**From:** Ian Stocks [REDACTED] **On Behalf Of** FRS Water and Access  
**Sent:** 20 April 2021 14:41  
**To:** Planning.Responses <Planning.Responses@arun.gov.uk>  
**Subject:** Hydrant condition - FG/50/21/PL Paddock House 44 Ferringham Lane Ferring BN12 5LU

**HYDRANT CONDITION CONSULTATION WITH PLANNING AUTHORITY**

Planning Ref: FG/50/21/PL

Address: Paddock House, 44 Ferringham Lane, Ferring BN12 5LU

Refuse Vehicle and Fire Tender
Turning Swept Path Analysis

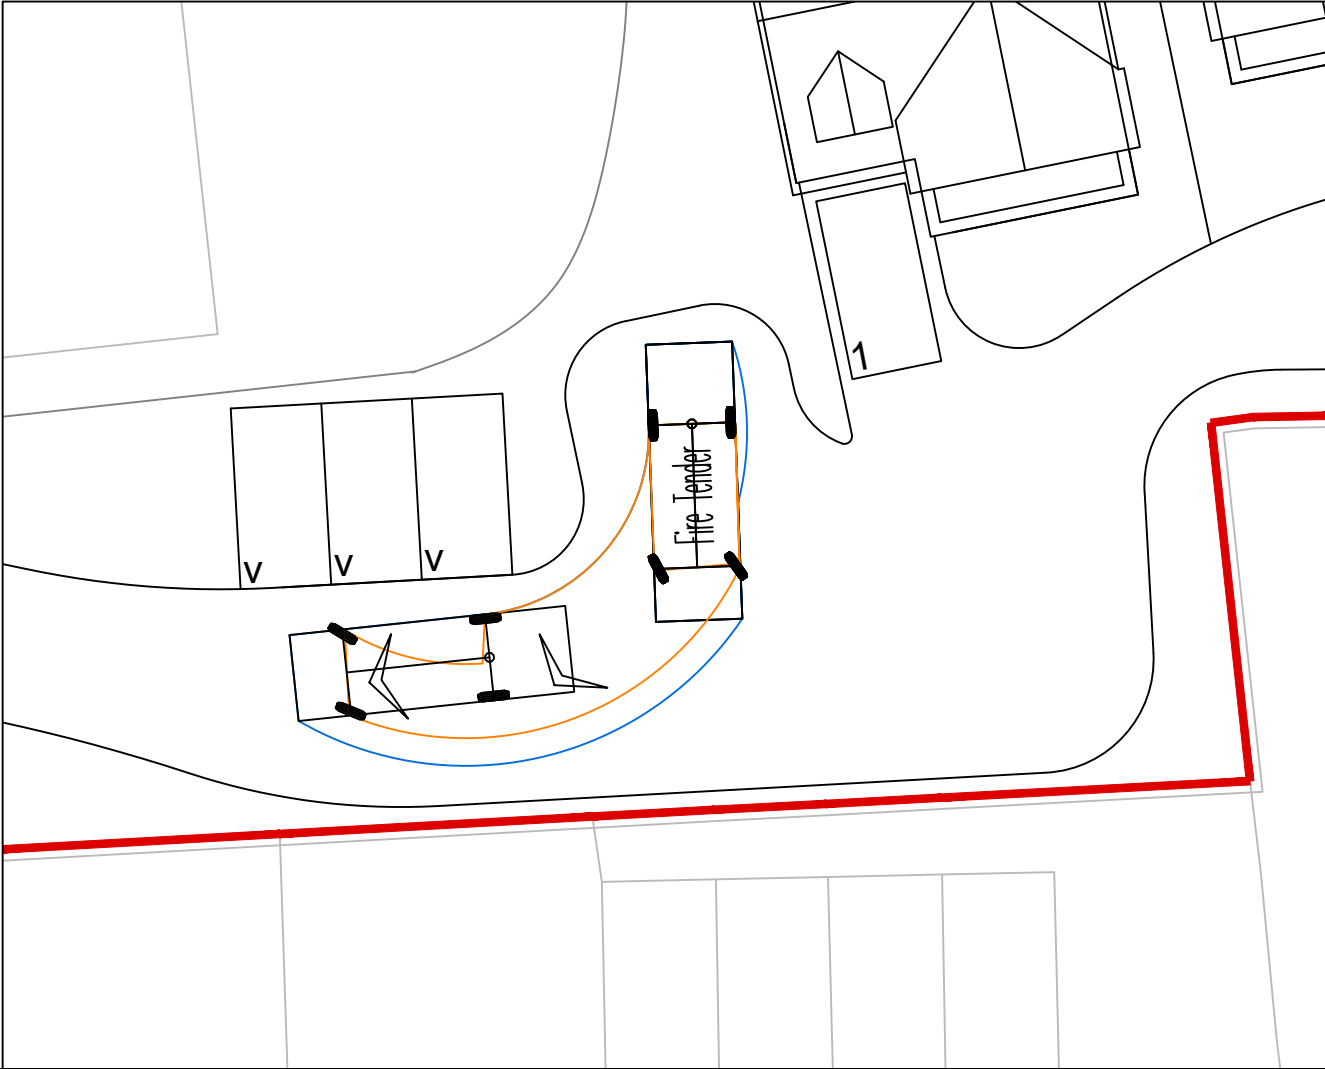
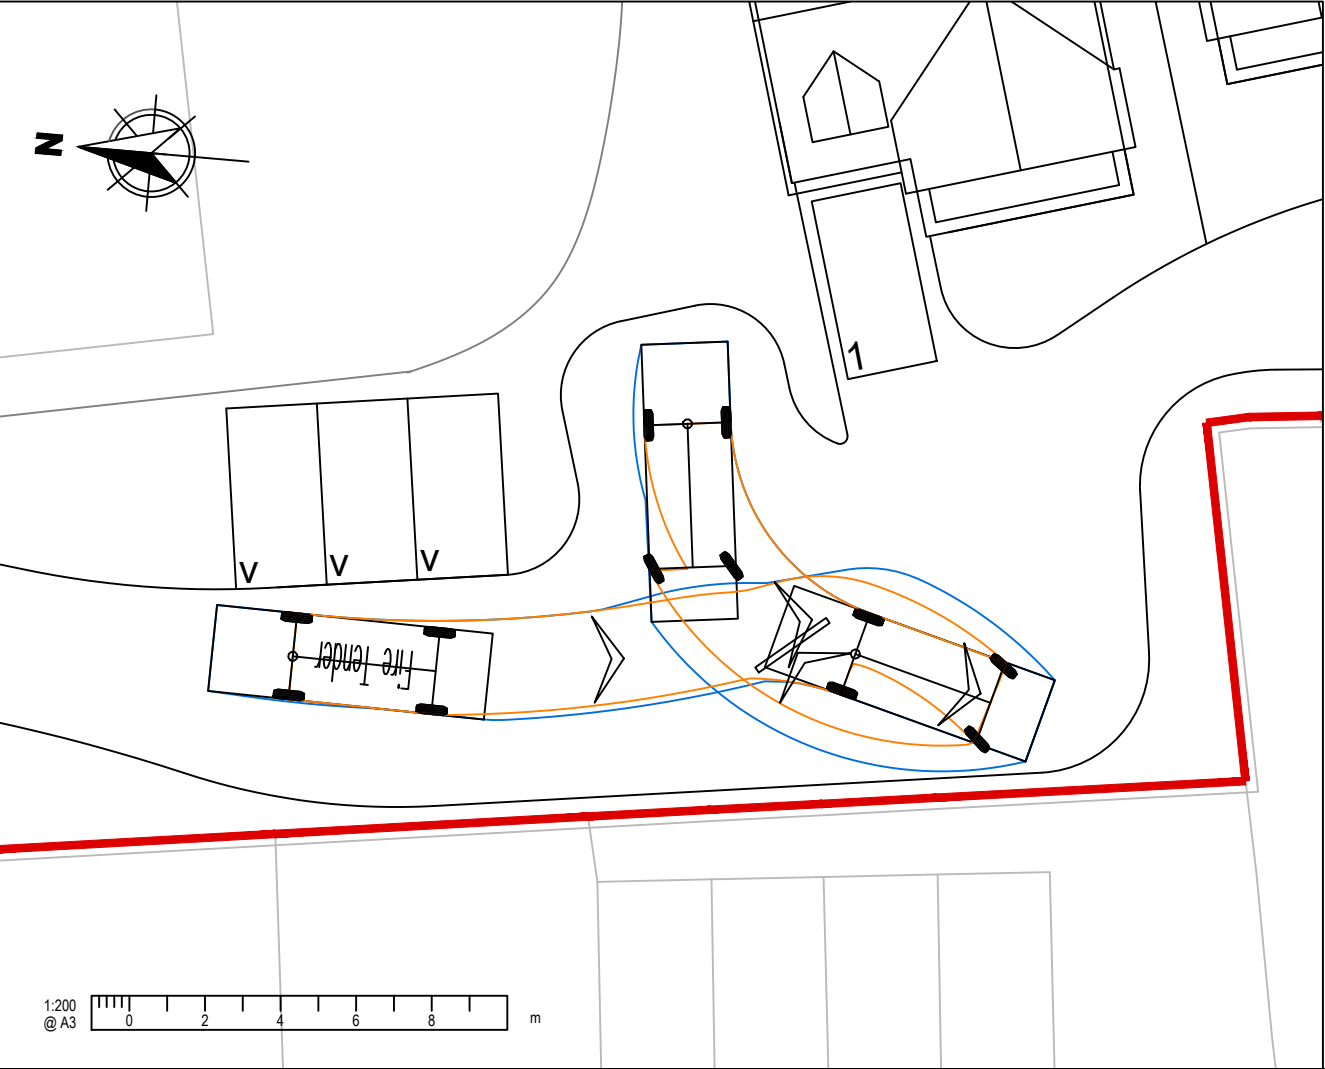
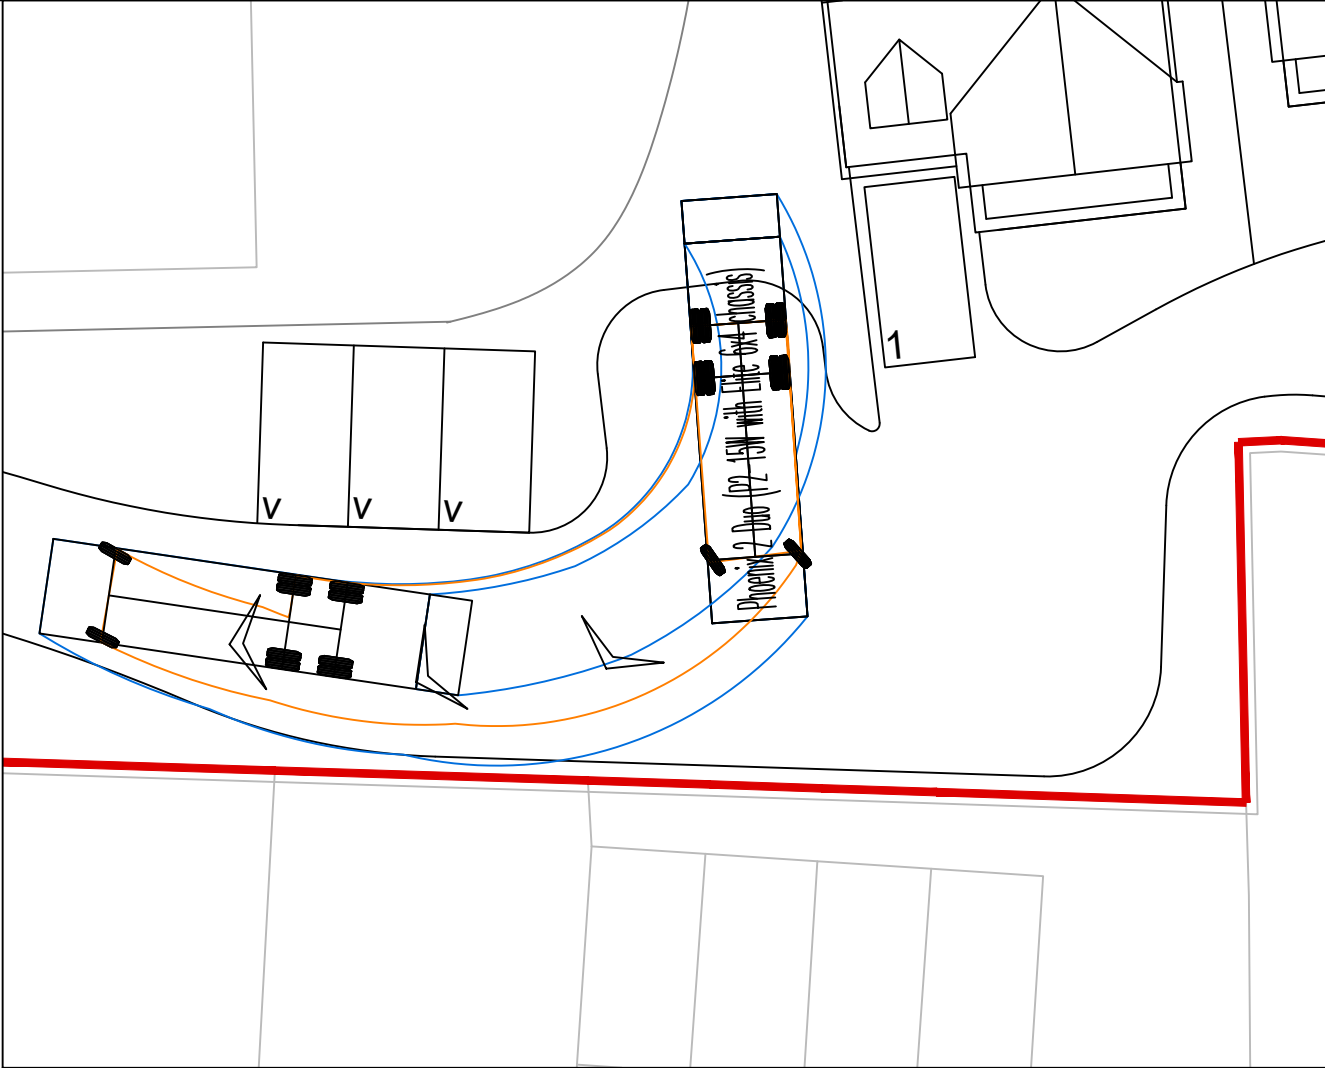
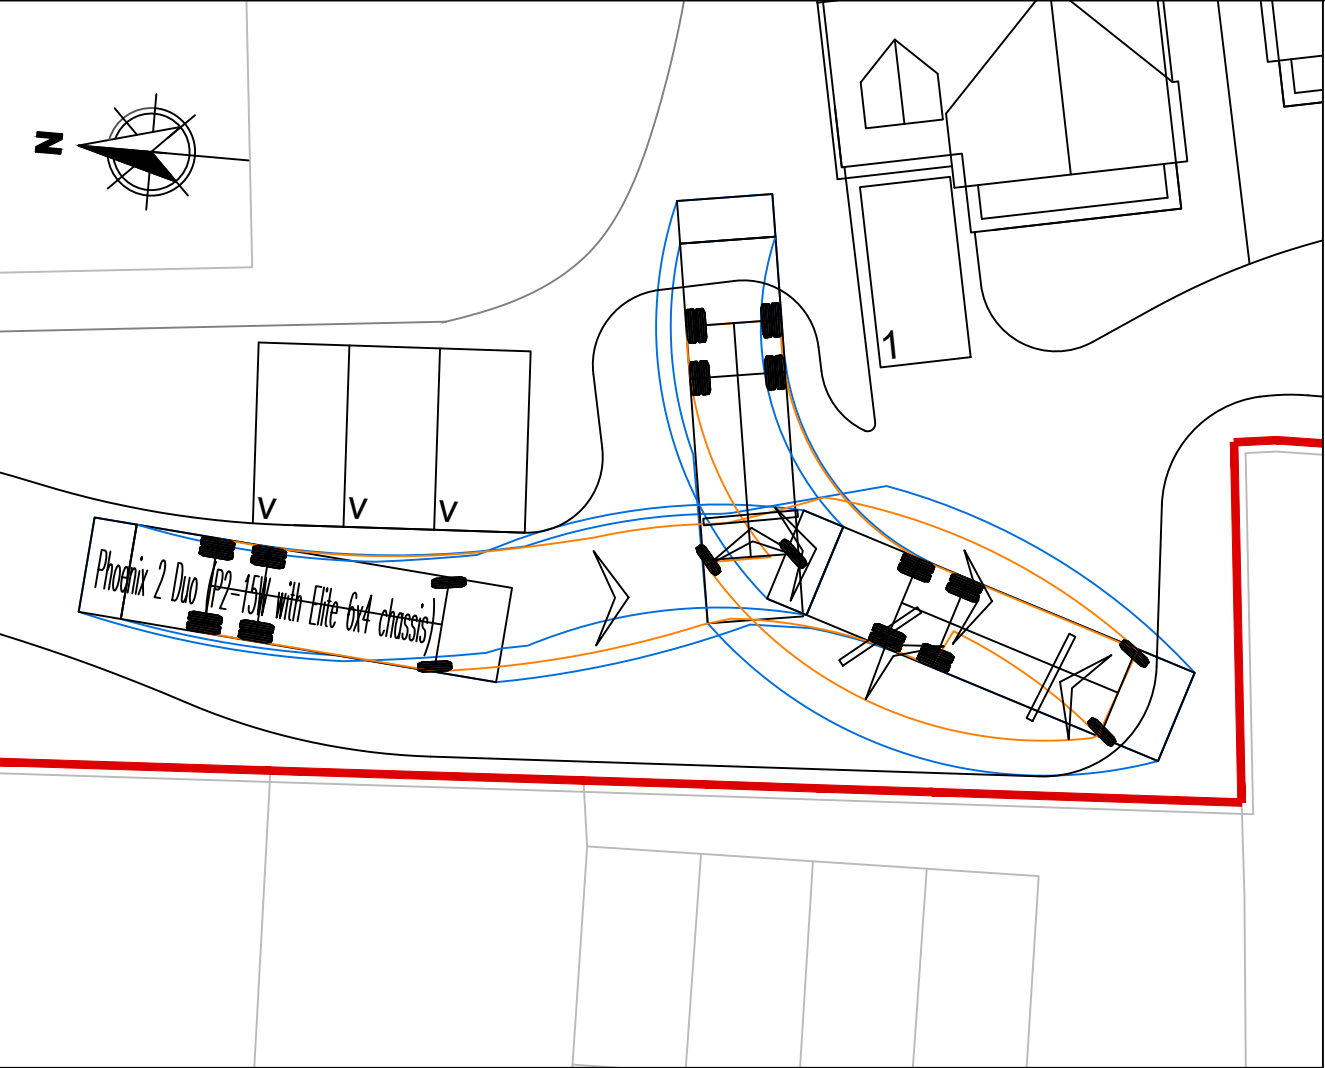
Evidence will also be required that Fire Service vehicle access meets with the requirements identified in Approved Document B Volume 1 2019 Edition: B5 Section 13, including Table 13.1 and diagram 13.1.
